Our Ref: A/165/19/DOC

Approval of details reserved by condition imposed under ref A/74/18/OUT relating to Condition Nos 4 - acoustic, 5 - external lighting, 7 - contamination, 12 - hedgerows, 14 - surface water drainage, 15 - discharge of flows, 16 - SuDs and 18 - watercourse or culvert.

The Laurels Dappers Lane Angmering BN16 4EN

Arun District Council have decided to **REFUSE details reserved by condition for the following reasons:**

**Project:** Oceanview Developments  
**The Laurels**  
Dappers Lane  
Angmering  
**Title:** Proposed Drainage Strategy Plan

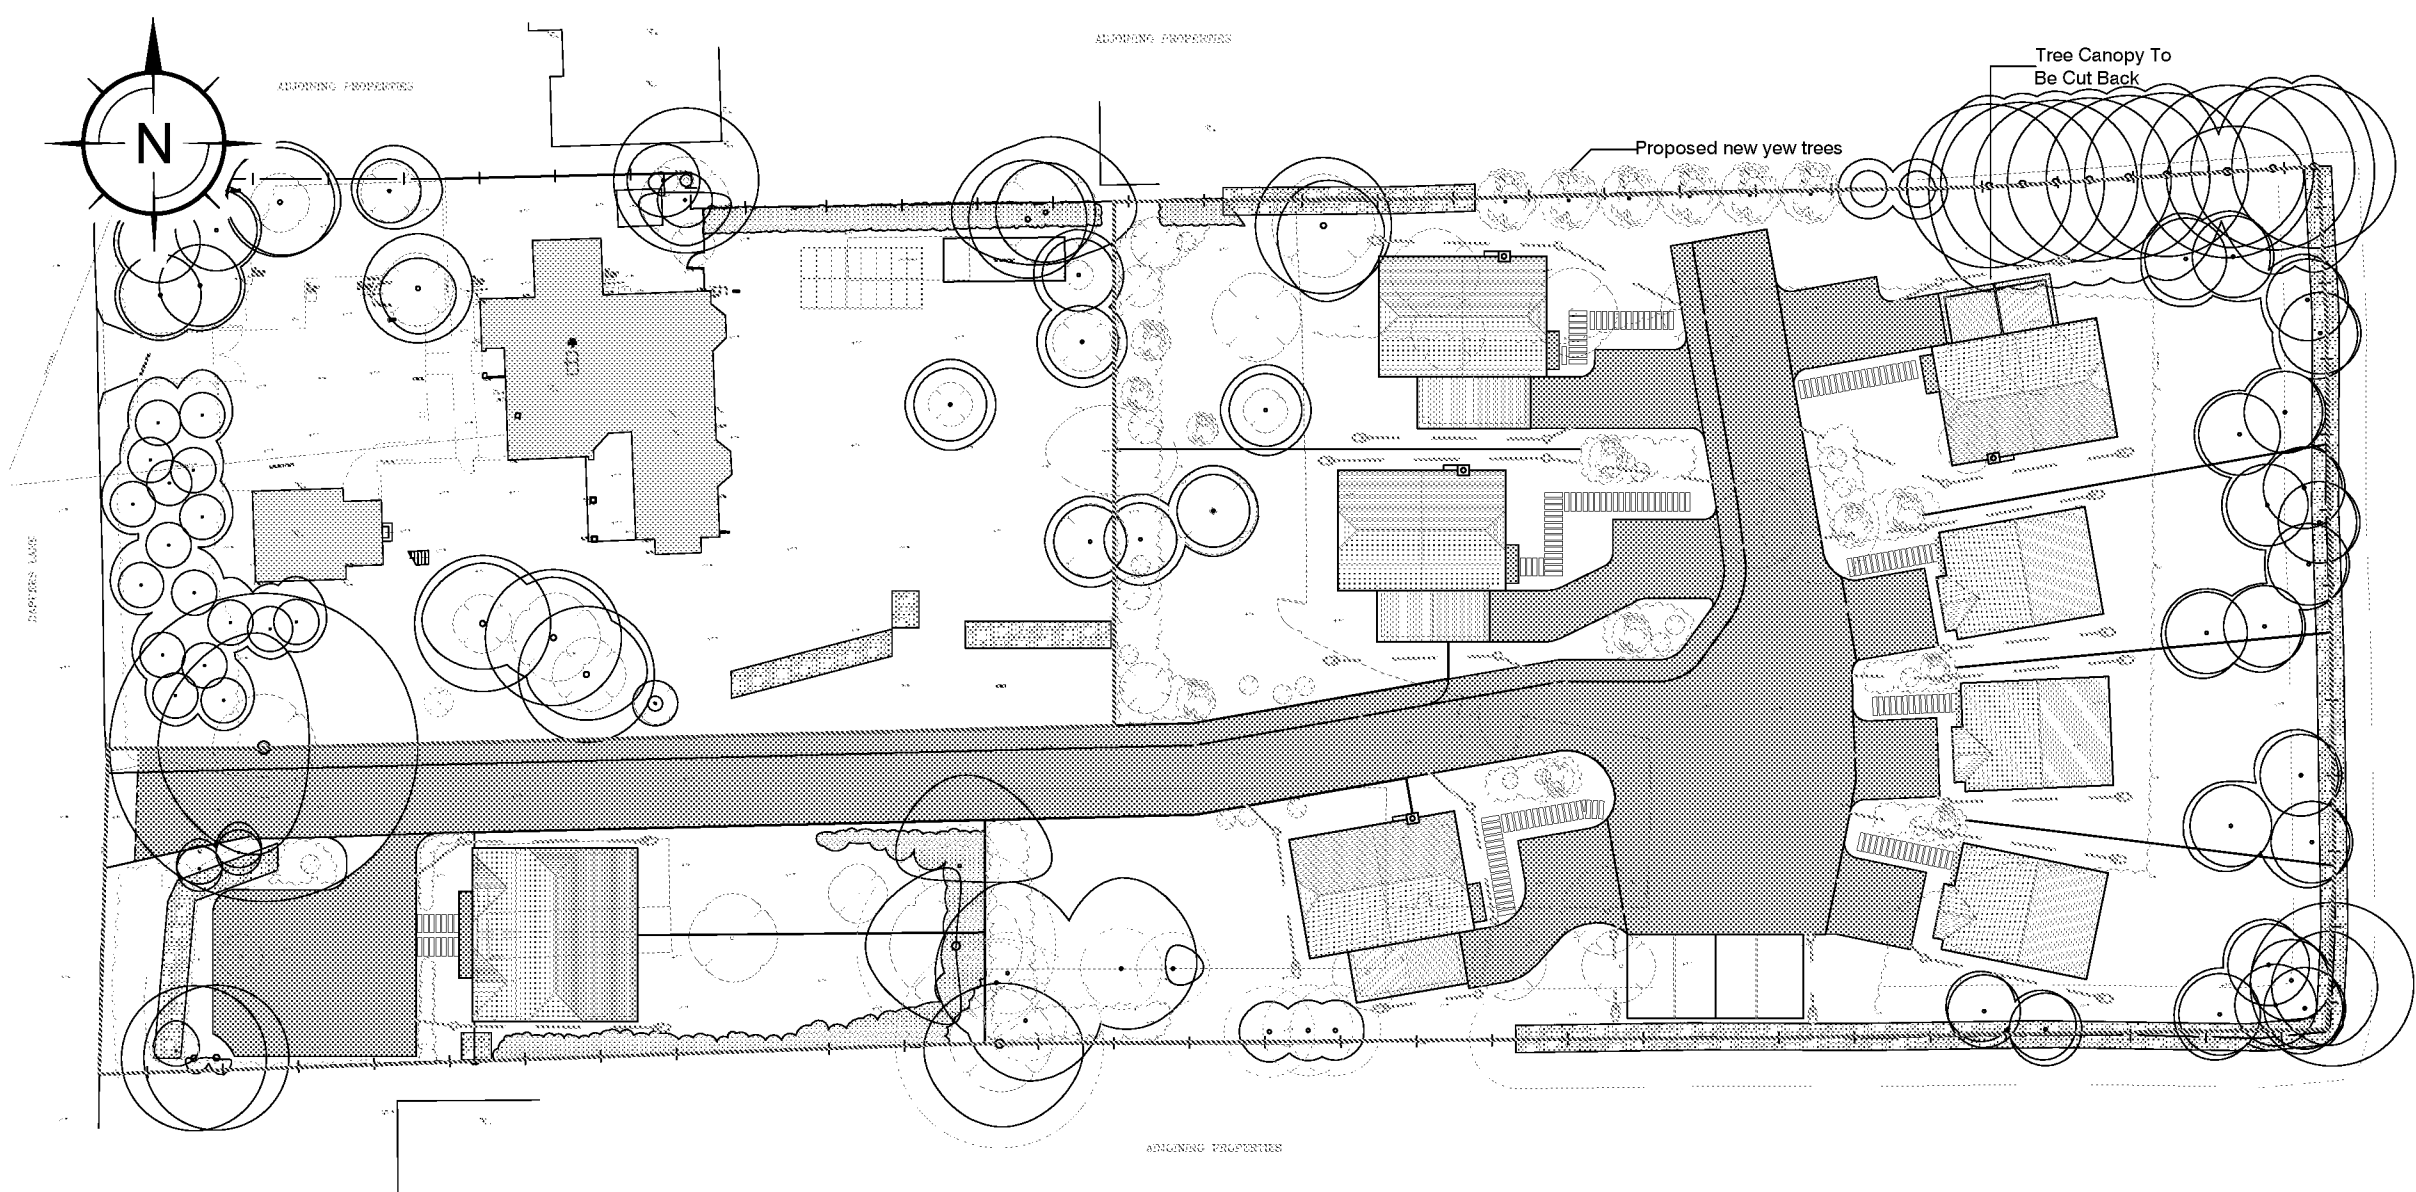
The applicant appears unaware that a culverted watercourse that runs along the western boundary, The following details should be provided so further comments can be made;

- a) A plan showing its location.
- b) Position/photos of any existing manholes on the culvert adjacent the site including immediately upstream/downstream.

- c) Manhole/culvert invert levels/cover levels.
 - d) Pipe diameter/material.
 - e) An internal CCTV survey inspection.
 - f) Proposed finished levels above the culvert.

- g) No new tree planting to be undertaken in the vicinity of the culvert. This needs to be made clear on the drawings.
2. Provide a fully detailed foul drainage proposals plan.

5. Whilst permeable paving is likely to be the way forward, due to the lie of the land, the design will need to ensure that water does not all run to the lower end of the site via the sub base, so the paving will need to be compartmented to ensure that water is contained within each structure. This arrangement will need to be fully detailed in terms of construction details and proposed finished/bed levels and supported by storage/infiltration calculations for each section. Please note that on the example calculation sheets, a porosity value of 0.95 has been used. Whilst this is acceptable for permavoid blocks, granular stone should be 30%, so the calculations will need to reflect the construction of each specific section of permeable paving. Where stone is to be used, this is to be type 3 material (of specified grading/no fines) wrapped in a permeable membrane.
